From: Mark Warwick
Sent: 09 September 2020 12:55
To: Amber Willard
Subject: Application Ref : AW/161/20/HH

I sustain my recommendation for REFUSAL (see previous comments in my report of 2nd September 2020).

I see that Mark Warwick has recommended refusal due to the impact on the Oak tree located off site on the highway verge.

Site Plan

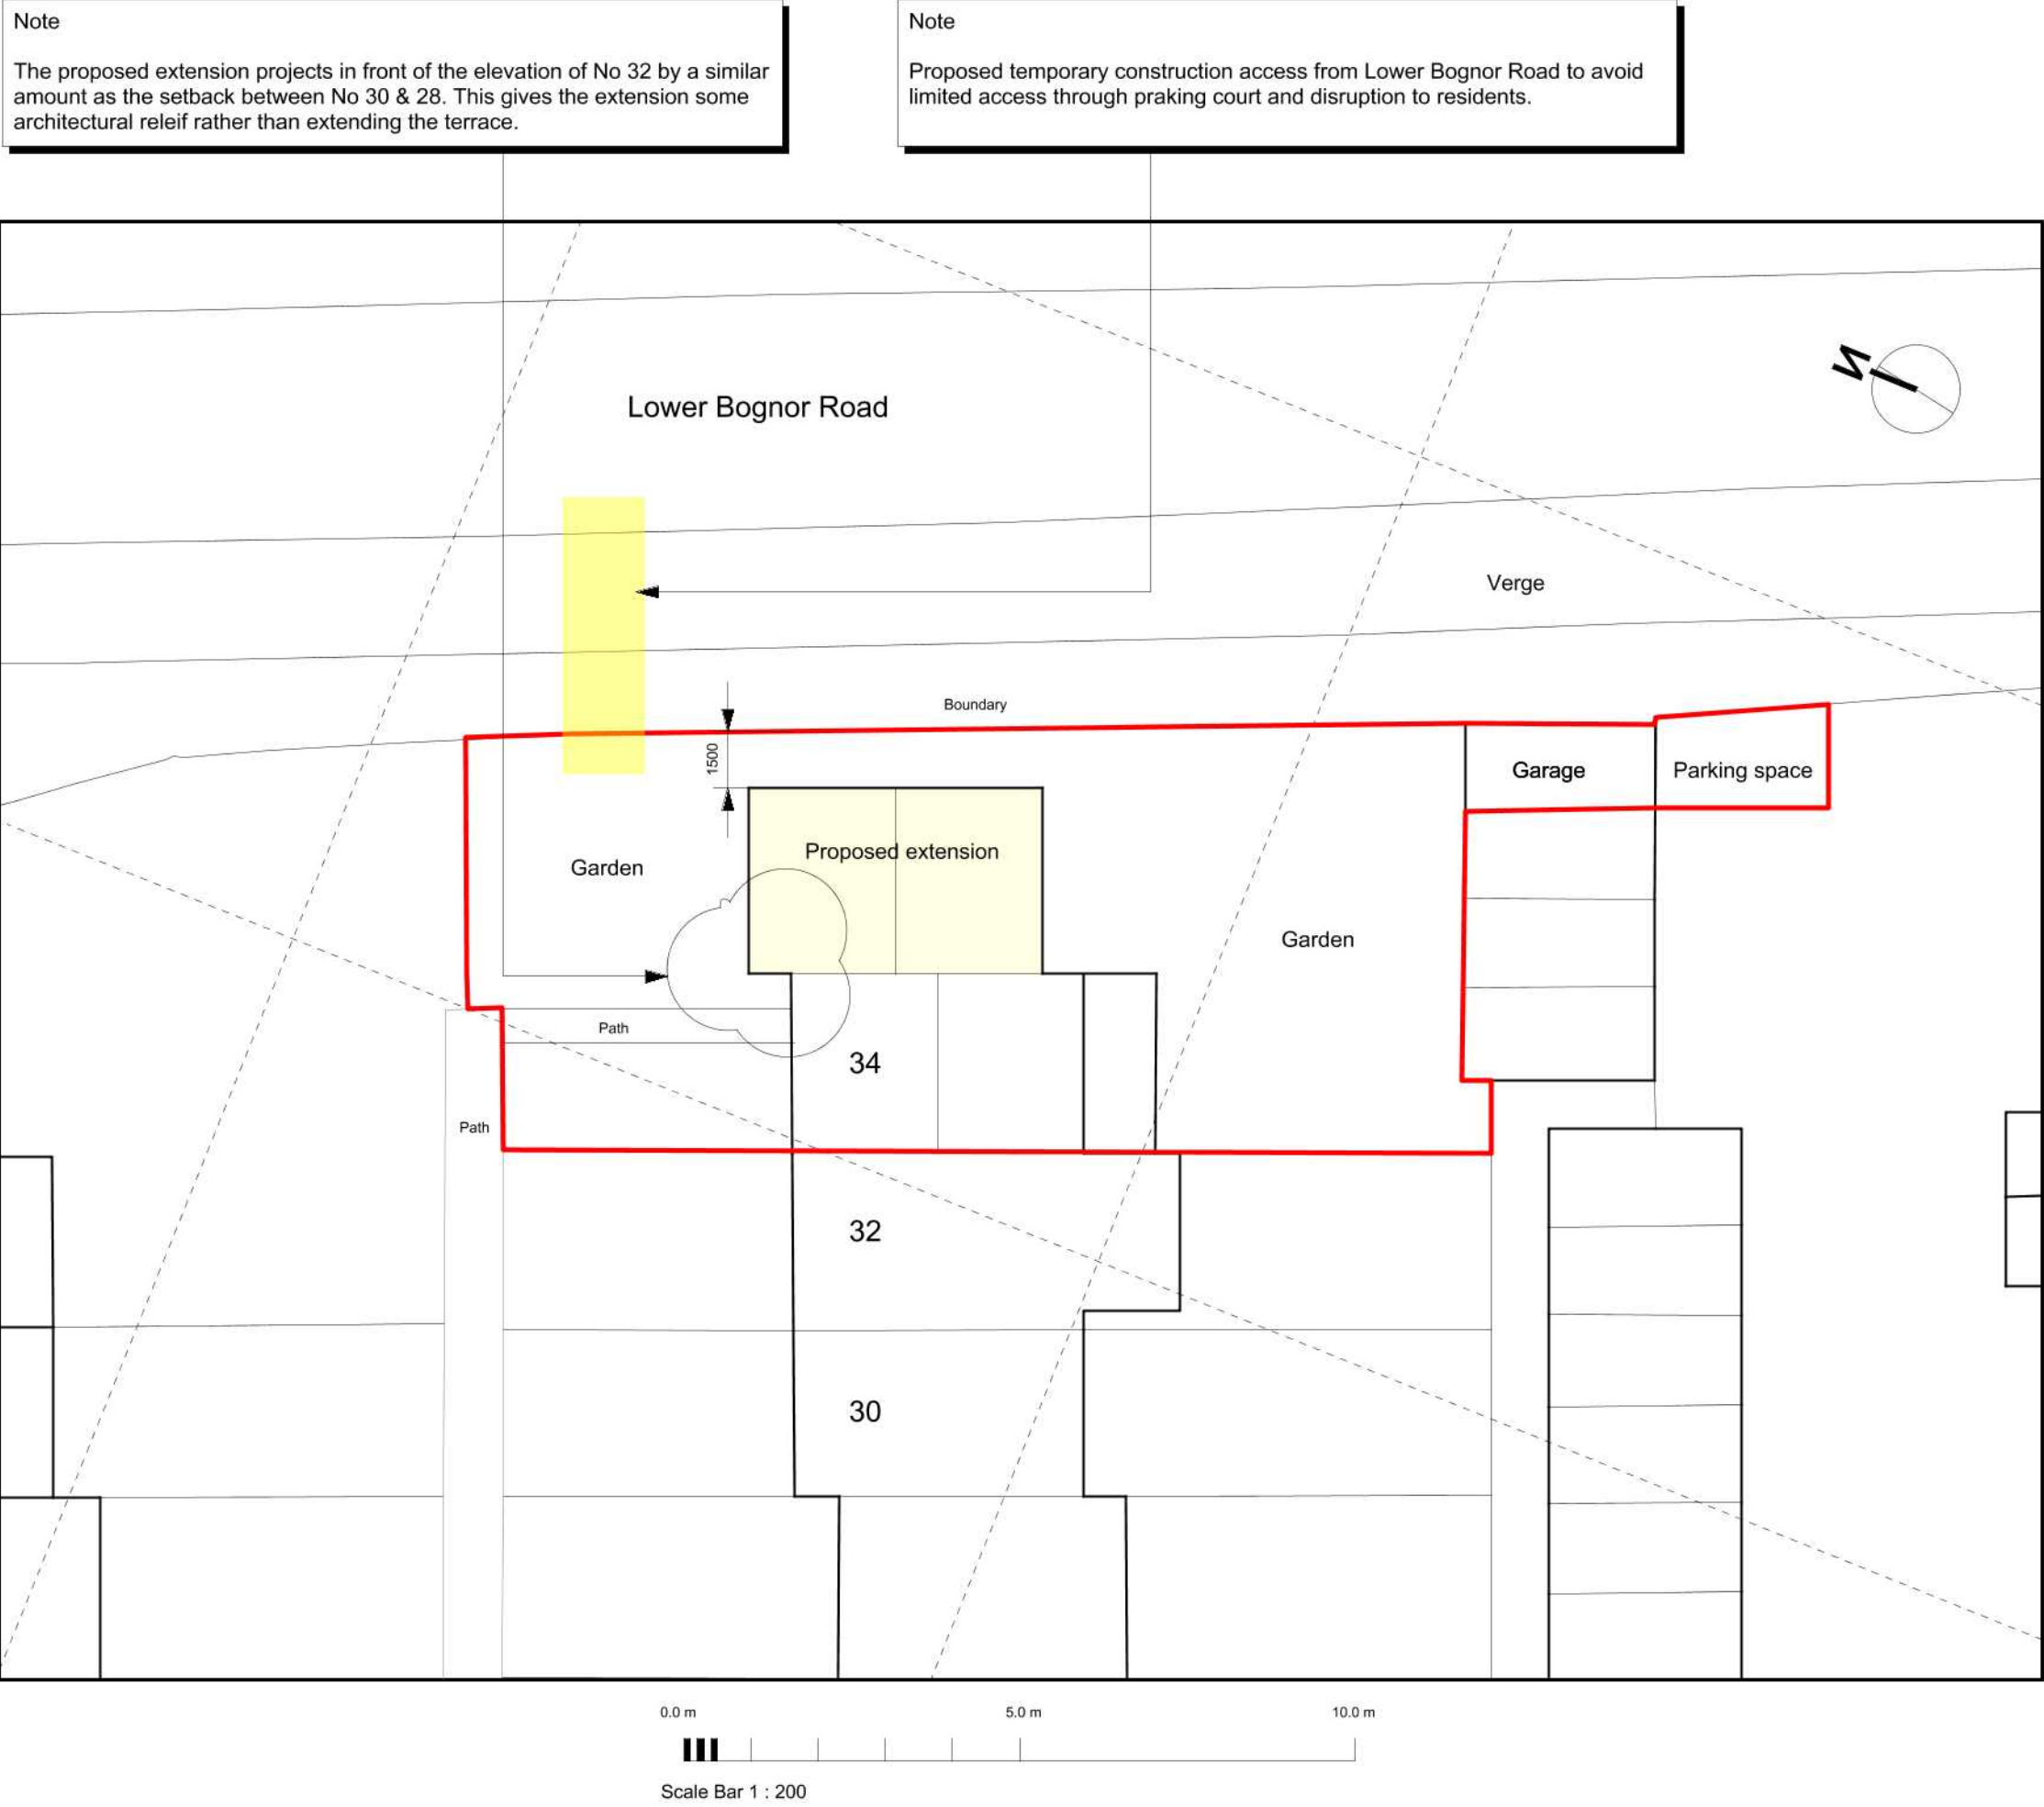
However he has attached a plan to show the RPA won't be affected.

Whilst this application relates to the same site (previous application AW/246/19/PL) and appears to be less intrusive and potentially damaging to established trees, it is a separate proposal. Not only do we require appropriate and tailored arboricultural submissions (reports and plans) to properly consider the application; the British Standard 5837:2012 recommends (and reminds us of a statutory duty to consider the protection and planting of trees when granting planning permission for proposed development) we seek that level of information. I refer Mr Blumer to p38 (Annex B) of the above Standard. It should be a straightforward exercise for the project arboriculturist to amend their report and plans on the applicant's behalf.

The footprint of the proposed extension does not impact on the RPA, as shown in green on the site plan, this is based on the Lizard Landscapes Tree Constraints drawings also attached and complies with current BS recommendations.

The use of circular Root Protection Areas is typical and usually adequate but in truth is rarely an informative representation in the built environment. In this case it clearly does not reflect the likely area which contains sufficient roots and rooting volume to maintain the tree's viability. A revised polygon which abandons the inclusion of carriageway/footway and captures much more of the existing garden and verges would be a realistic representation. It follows that this proposal would involve intrusion into the root protection area of the important off-site oak (their ref. T05) and that needs to be properly considered in a Arboricultural Impact Assessment & Method Statement and illustrated on a Tree Constraints/Protection Plan.

In the light of the above I do not agree with Mark's, recommendation for refusal, as the development will have no impact on the oak tree.
